Consultation Response from KC, Highways Development Management
2021/92658 The Abbey, 171, Abbey Road, Shepley, Huddersfield, HD8 8DY
Erection of single storey rear extension, formation of extended access driveway, erection of railings and associated alterations
Date Responded: 30/07/21
Responding Officer: J Turner
Responding Ref: K12-39/22

This application seeks approval for the erection of single storey rear extension, formation of extended access driveway, erection of railings and associated alterations at Abbey Road, Shepley.

PROPOSED SITE PLAN
SCALE 1:250

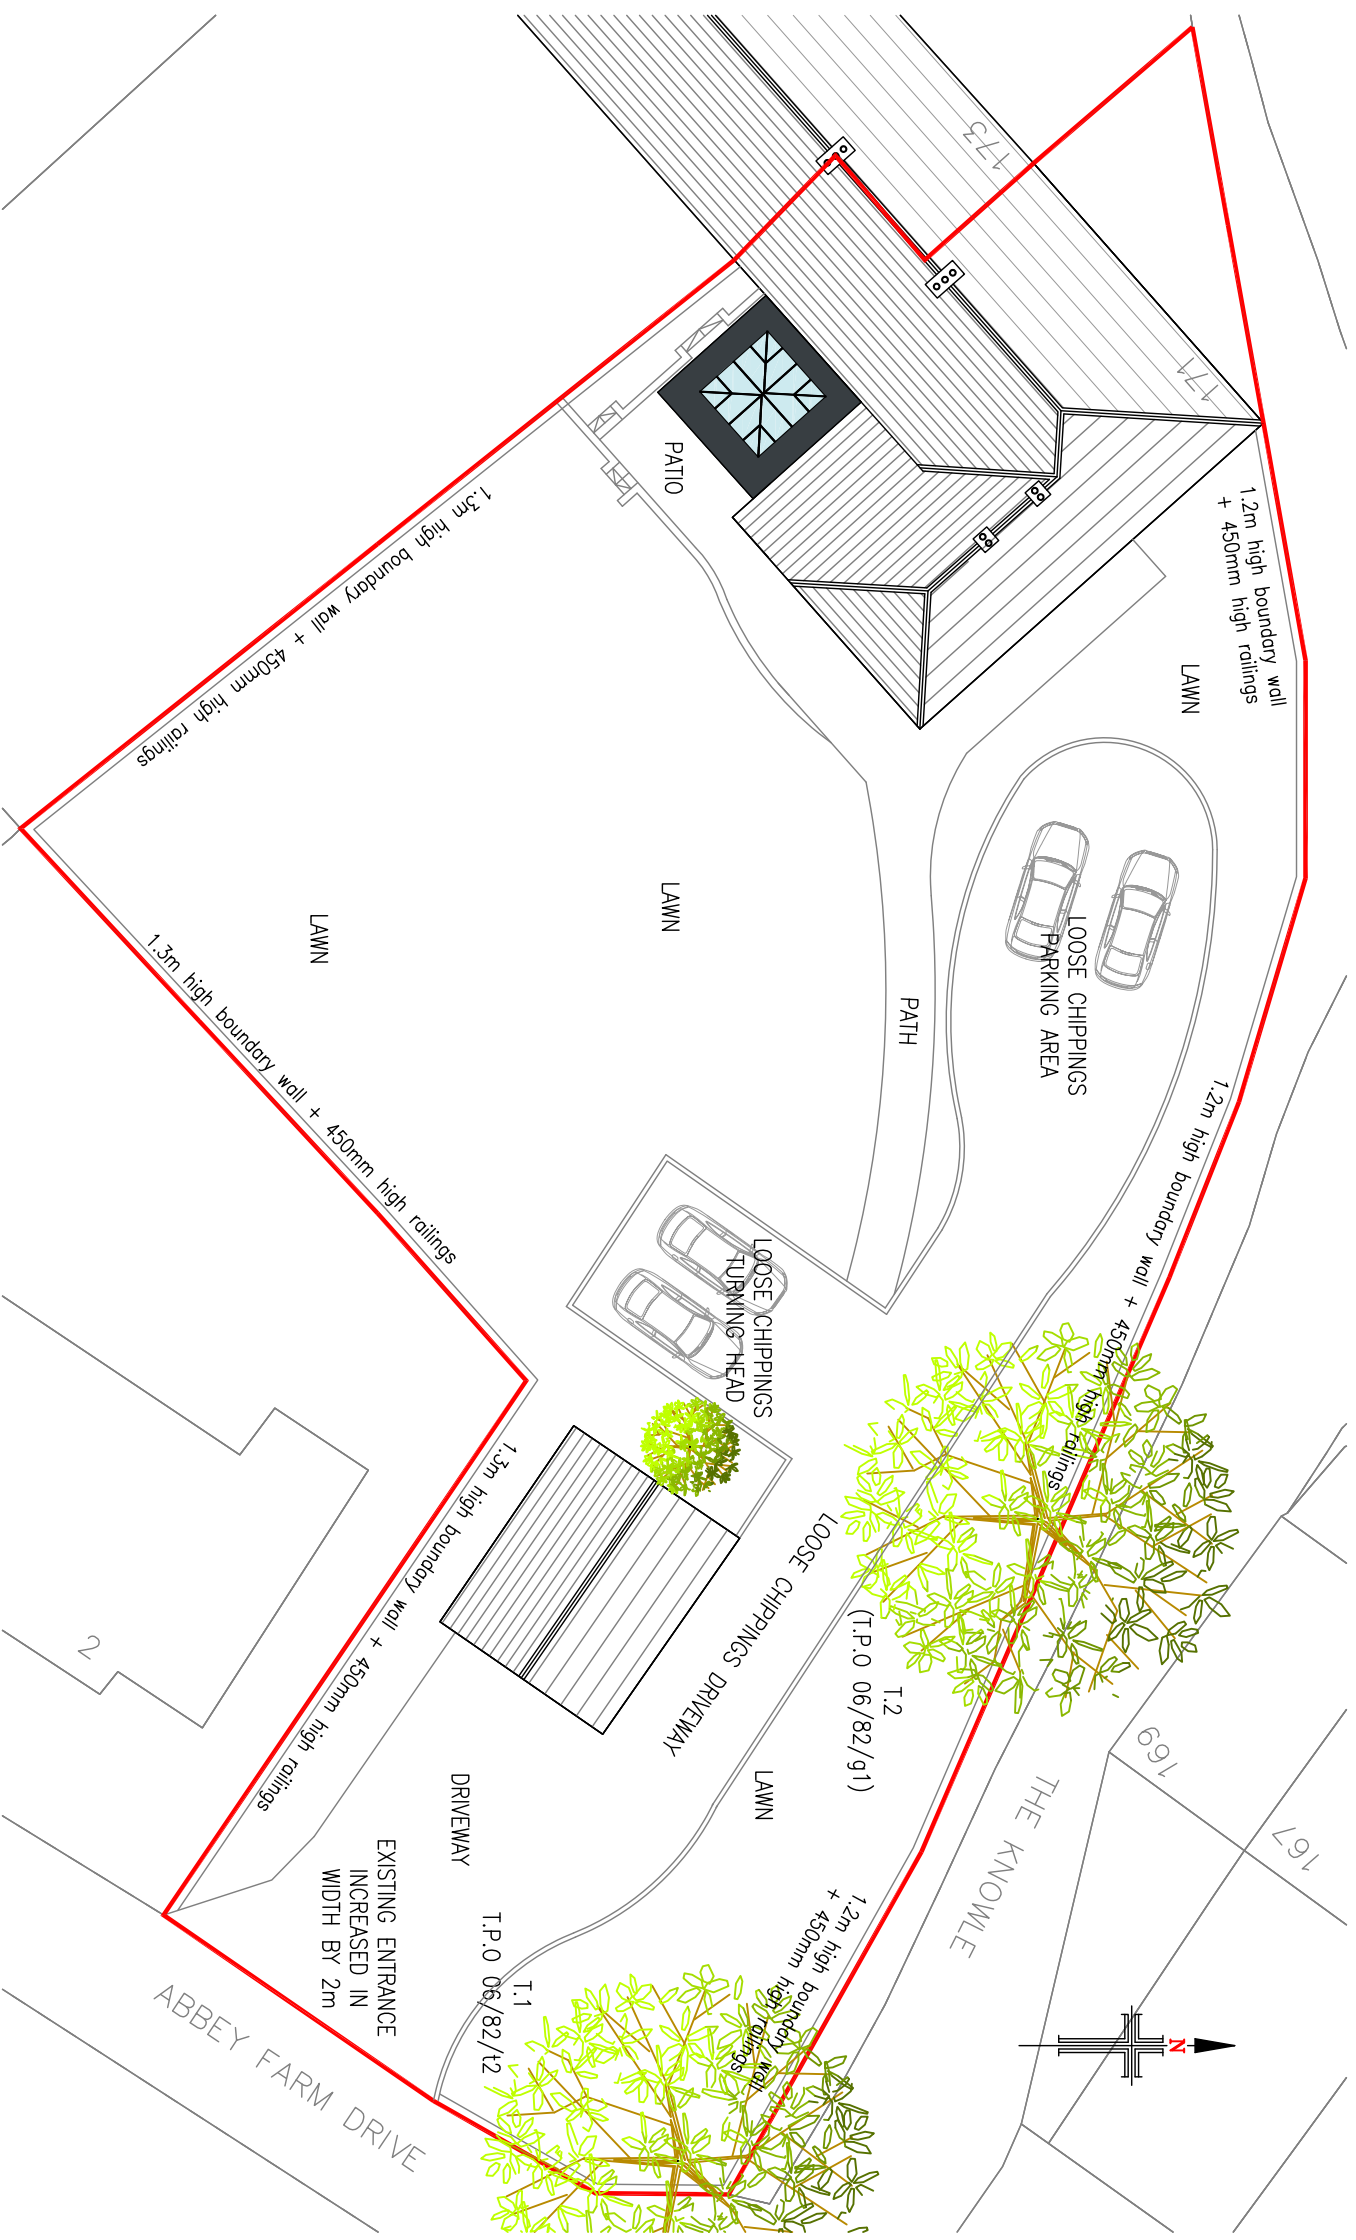
The proposed development improves the off-street parking facilities of the host dwelling, providing surfaced driveway for at least four vehicles. The access onto Abbey Farm Drive is too be widened by 2m.

Highways DM would ask that the first five metres of the driveway is hard surfaced so that loose chippings are not transferred onto the public highway.
